April 6, 2023

RE: Permit #2209-088 Houtchens SUB2 Review. [Comment Response Letter](#)

C-101 Grading and Drainage Plan

DRAINAGE & EROSION CONTROL PLAN

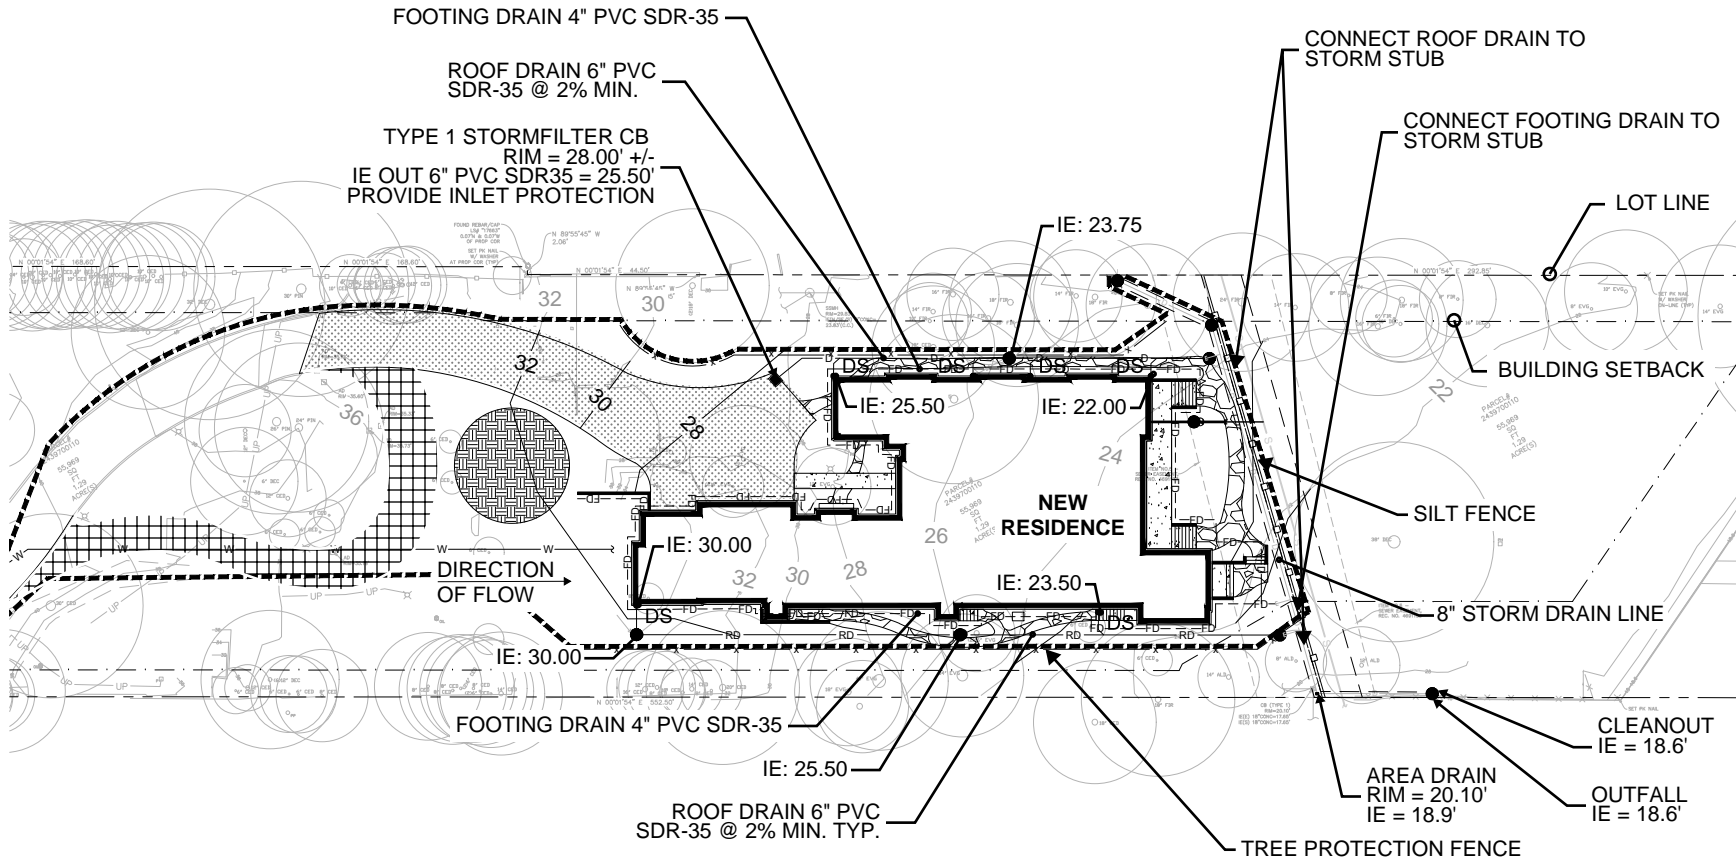
1. Please show the location for the RPBA (City is aware that RPBA will need to be located further than 50' from water meter location due to length of driveway).

2. Specify the footing drain IE at the building point of connection.

3. Repeat comment from SUB1: Excavations will be below or near OHWM - please clarify how these areas will be de-watered and how this runoff will discharge on the plan.

[BCRA Response: RPBA now shown on C-101.](#)

[BCRA Response: Footing drain IE at building point of connection now specified on C-101.](#)

[BCRA Response: Excavation dewatering now addressed in TESC note 2.](#)
